Planning Department  
Welwyn Hatfield Borough Council  
The Campus  
Welwyn Garden City  
AL8 6AE

**Planning Application Reference: 6/2022/1106/FULL**

We have some concerns associated with this application and wish to object on the grounds set out below;

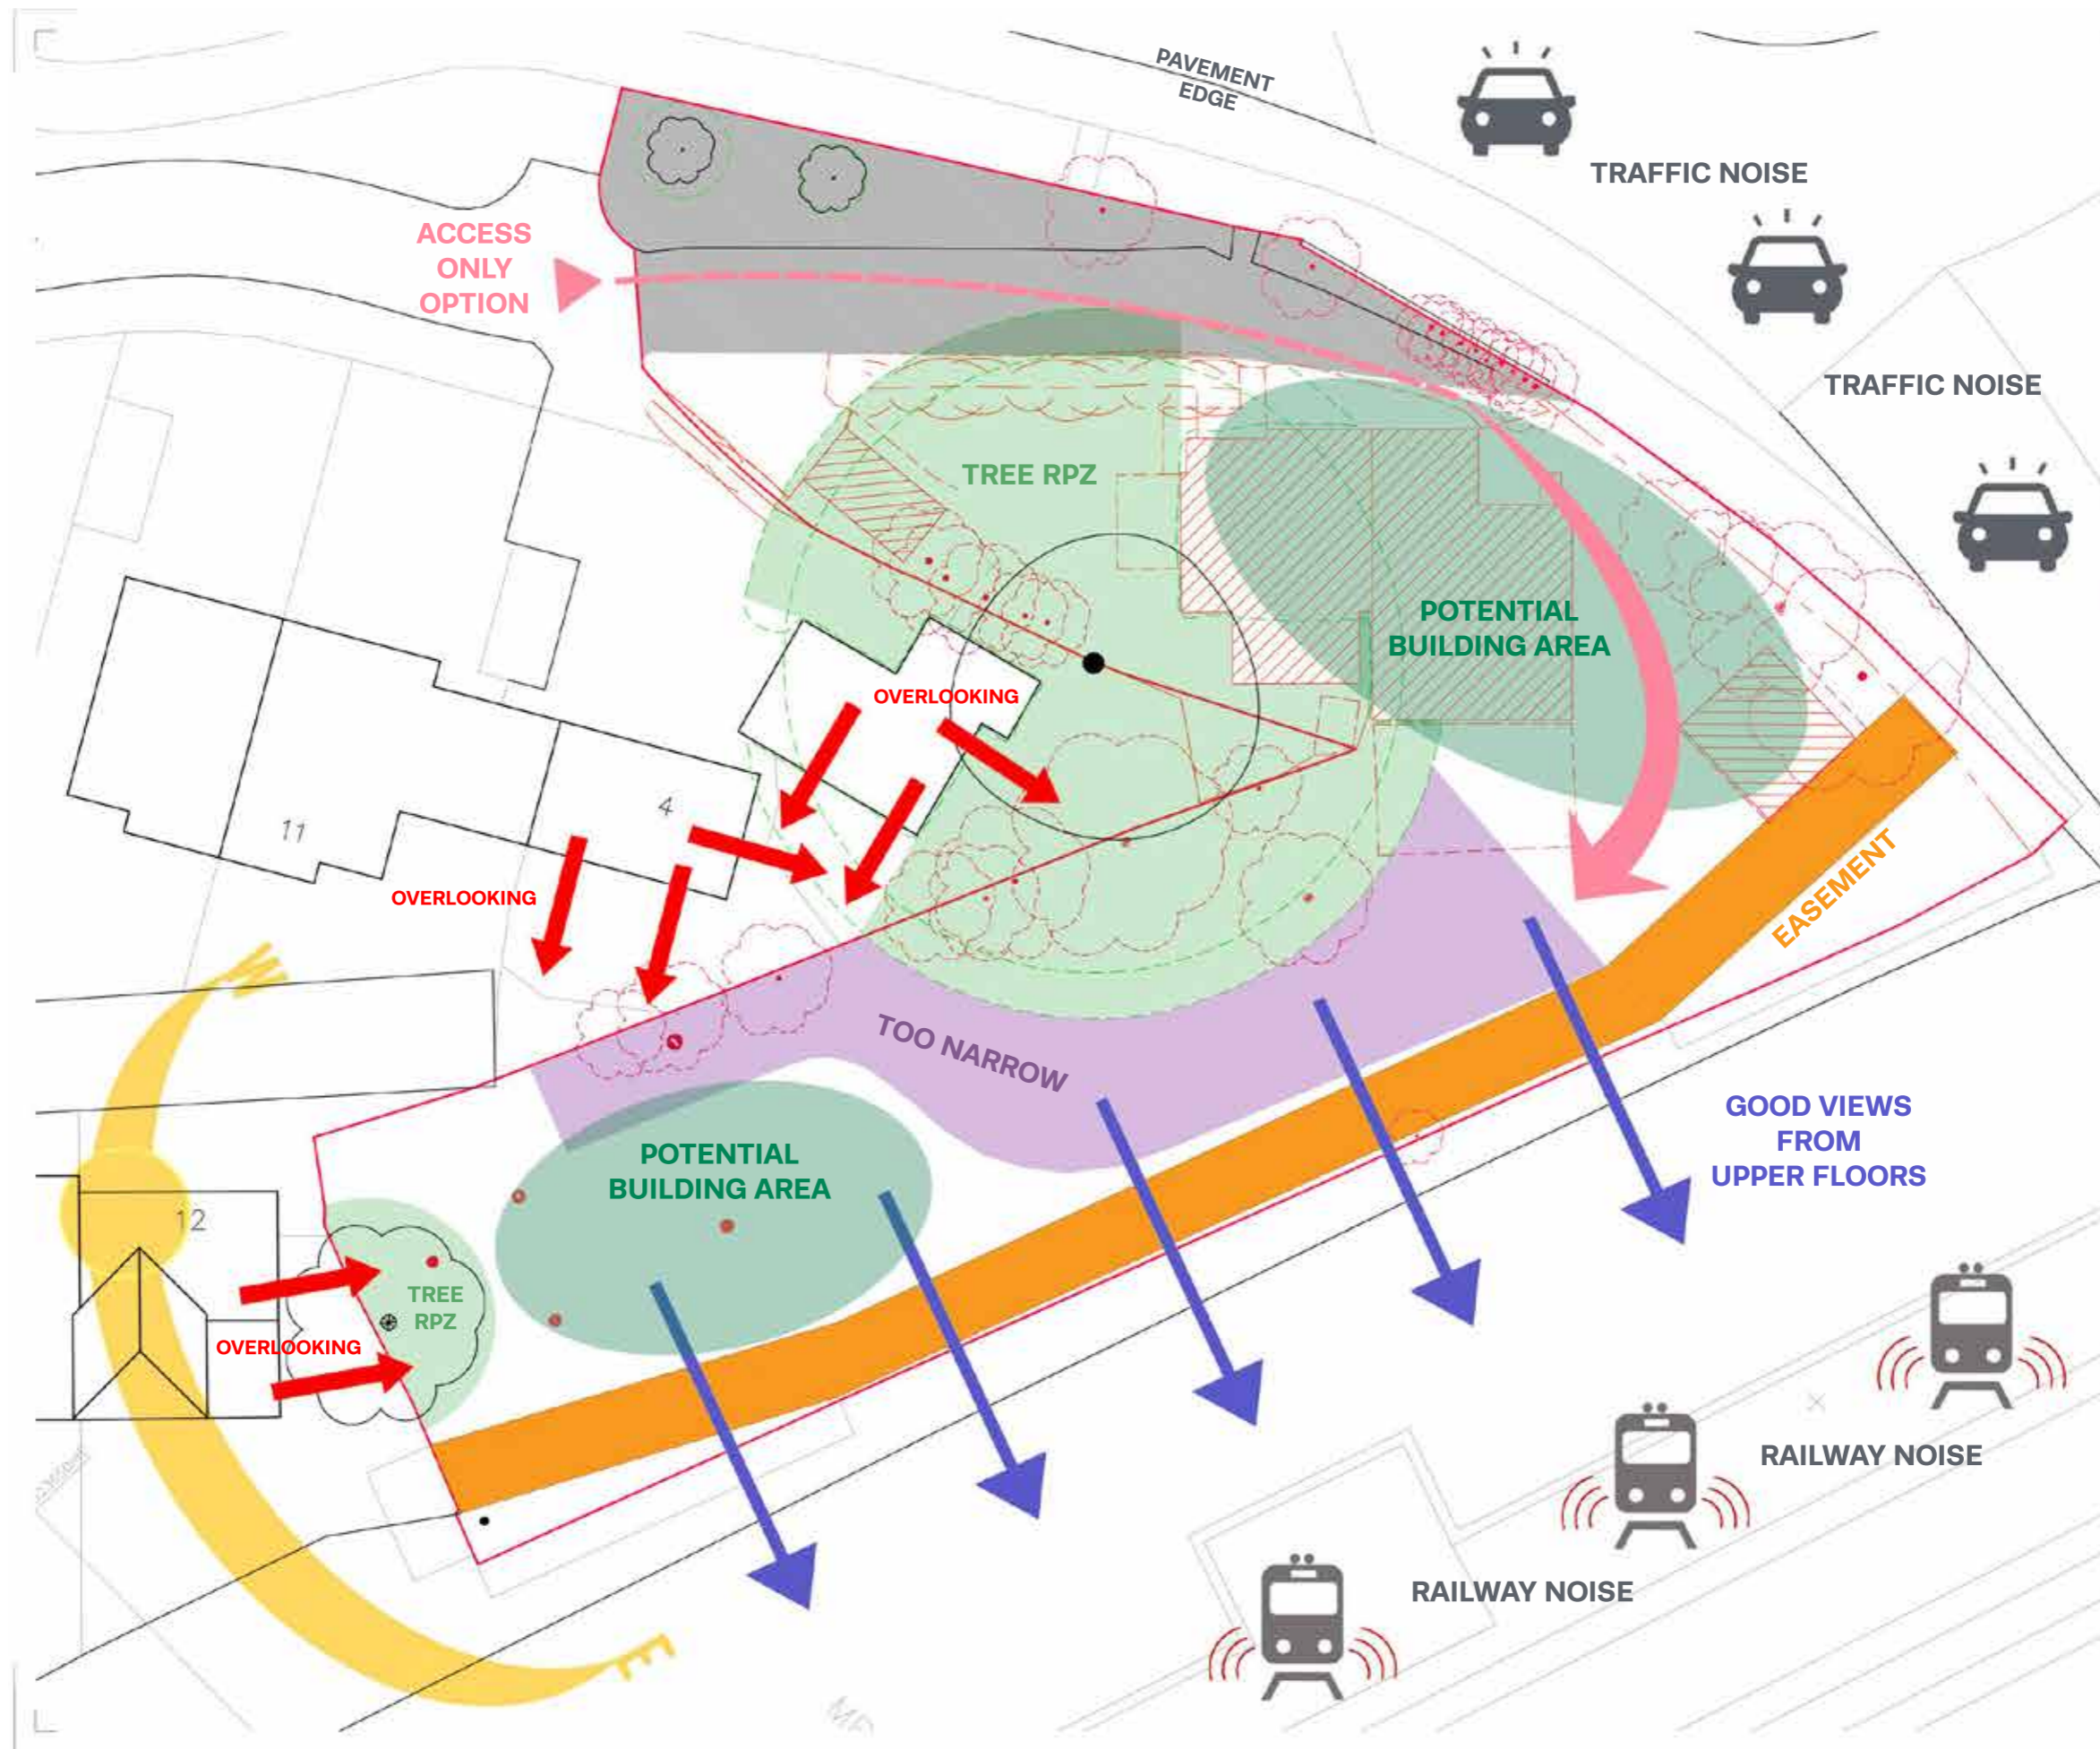
- 6) The Constraint Plan on page 7 of the RM Architects Design and Access Statement states that our garden at [REDACTED] Longcroft Green is already overlooked, presumably by a window on the side of [REDACTED] Longcroft Green (see image 1 below), however this is not correct as there is no window on that side of the house at number [REDACTED] (see image 2 below) meaning that our rear garden is currently not overlooked from any direction.
-

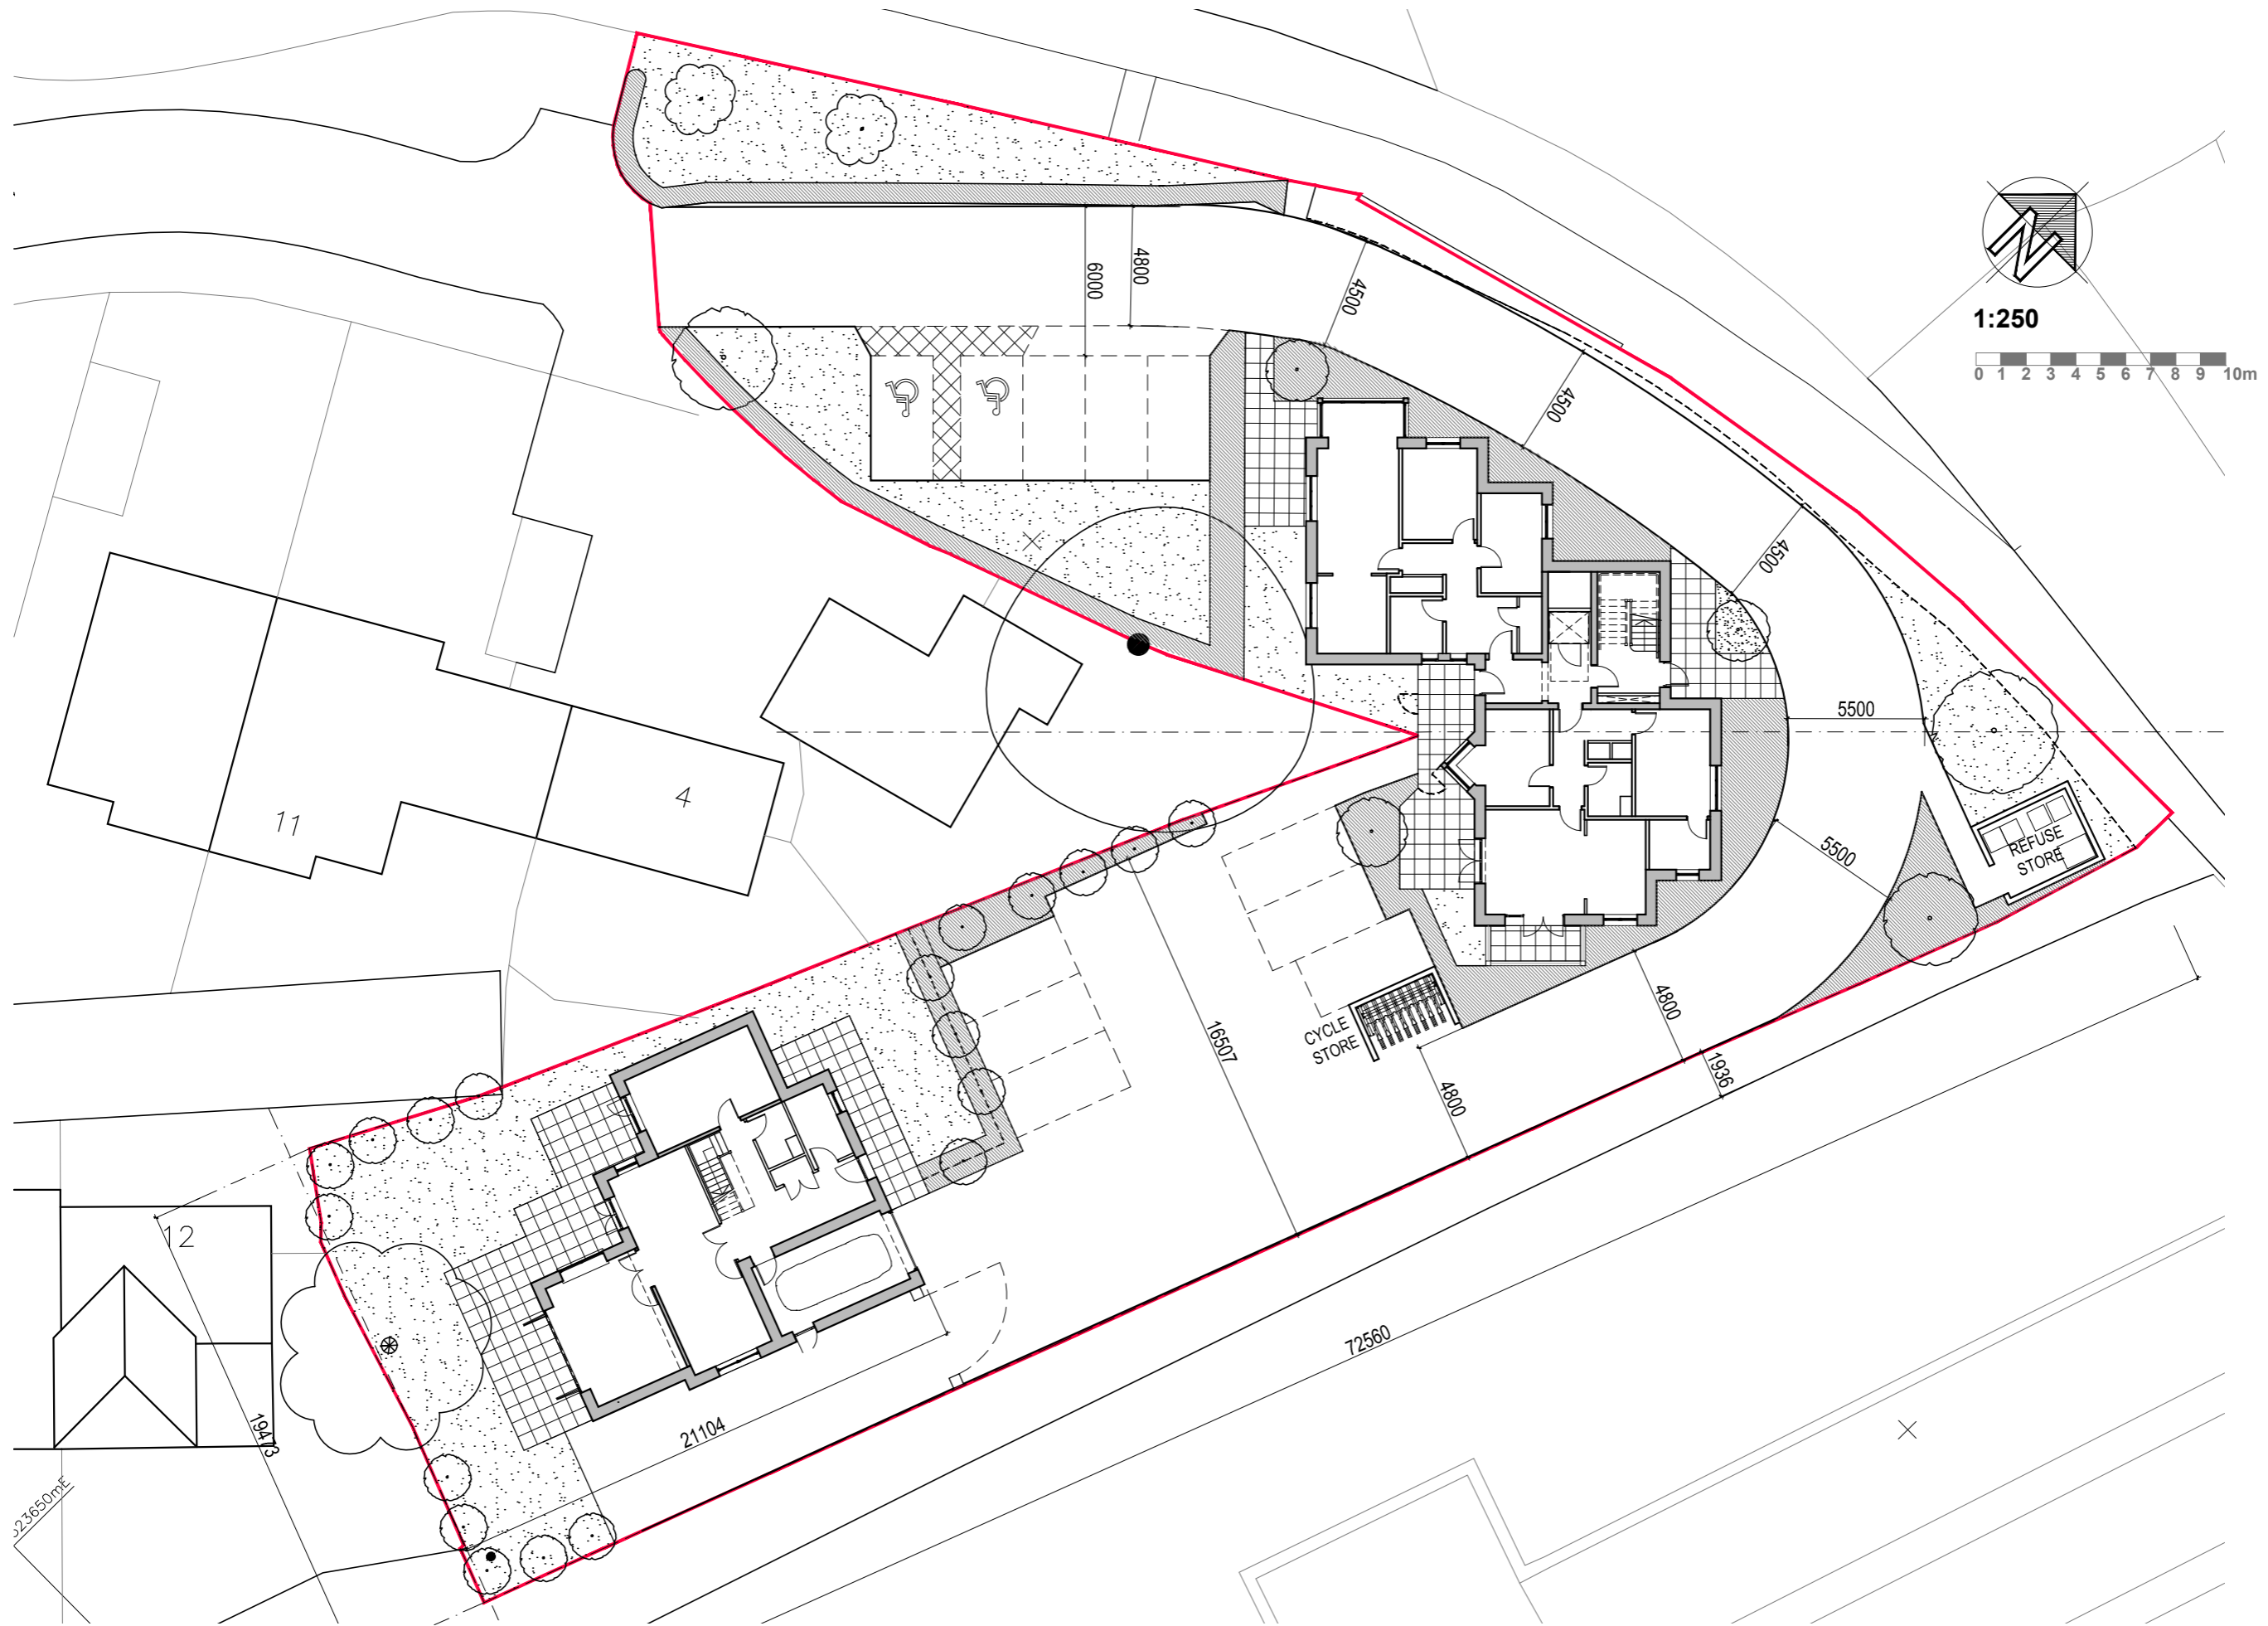
plans to adequately replace these with mature alternatives, particularly with regards the shrub/hedgerow at the front and side of our property. The Proposed Site Plan on page 9 of the RM Architects Design and Access Statement states that there is an "existing closeboard fence" running along the entirety of that boundary when in fact there is not. Loss of this shrub/hedgerow, with no proposed replacement, would further impact on our loss of privacy and significantly expose the front of numbers [REDACTED] Longcroft Green to the main road. This is contrary to policy D8: Landscaping in the 2005 Welwyn Hatfield District Plan.

SOUTH ELEVATION

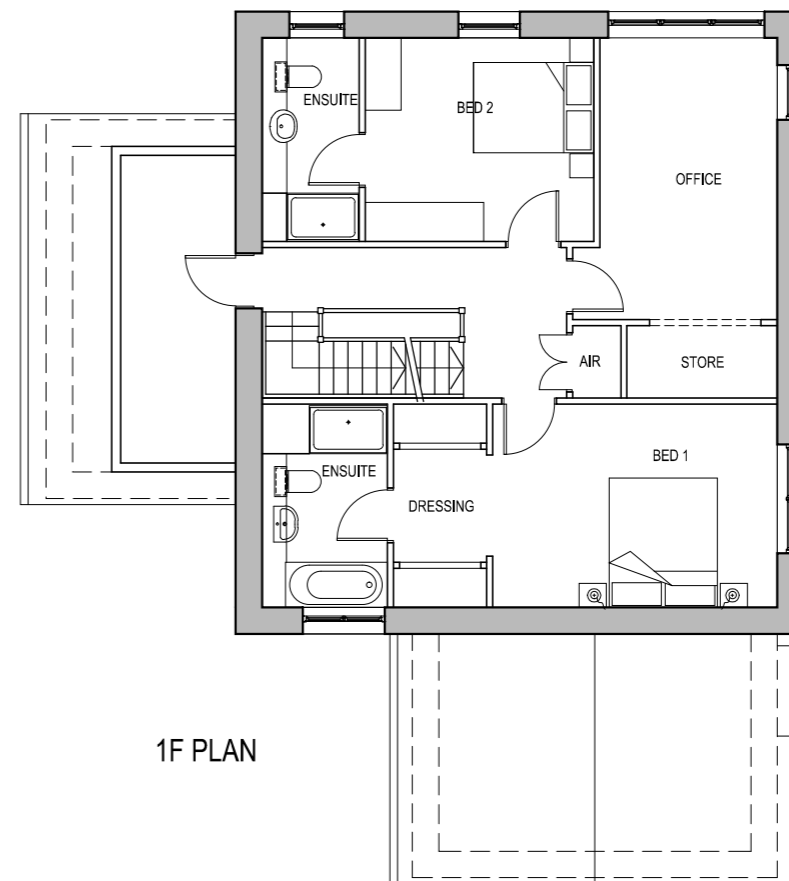
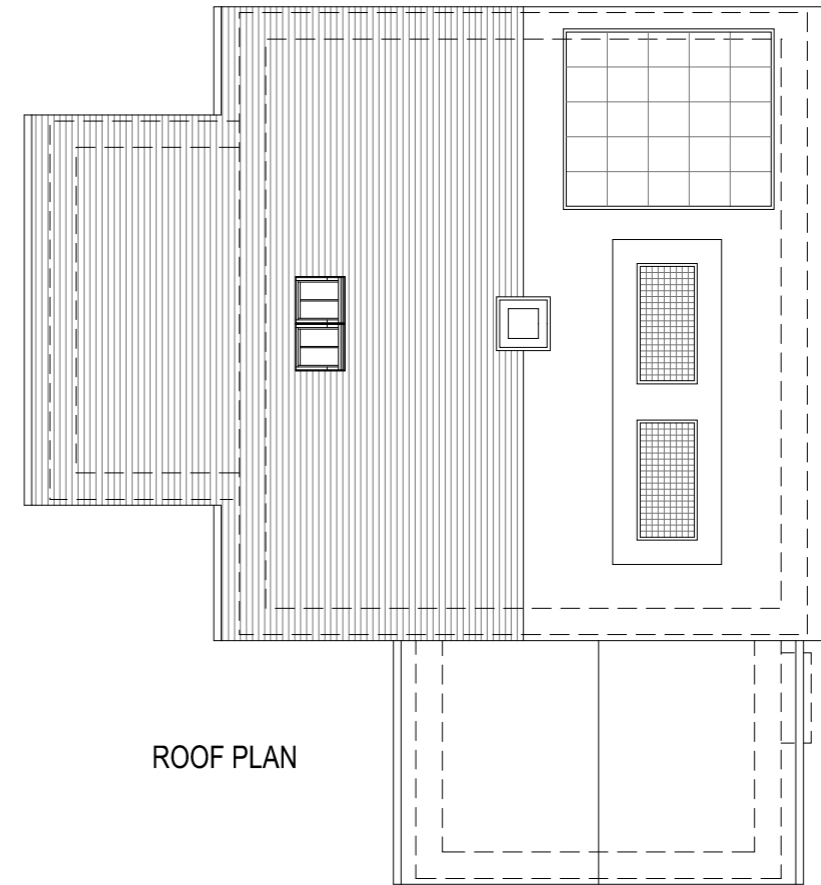
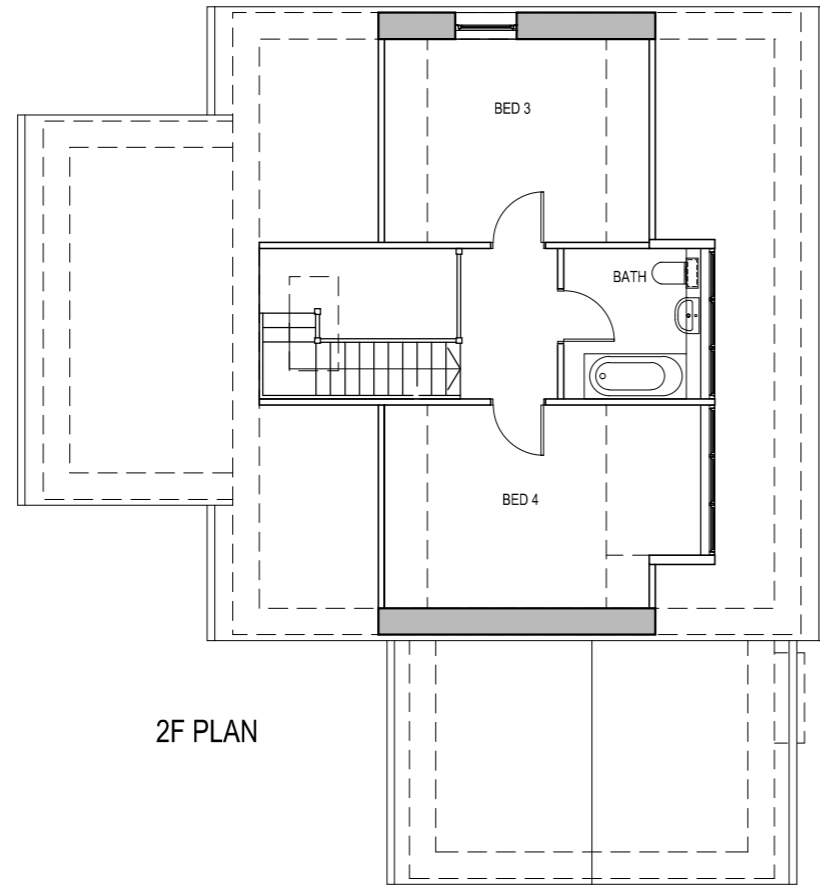
The upper windows and balconies, on the south and east elevations respectively, of the proposed apartment block would significantly overlook our garden and bedroom at number ■ Longcroft Green. Anyone standing on the east elevation balconies and looking to their right would have an unobstructed view into our main bedroom. This is contrary to policy D1: Quality of Design in the 2005 Welwyn Hatfield District Plan.
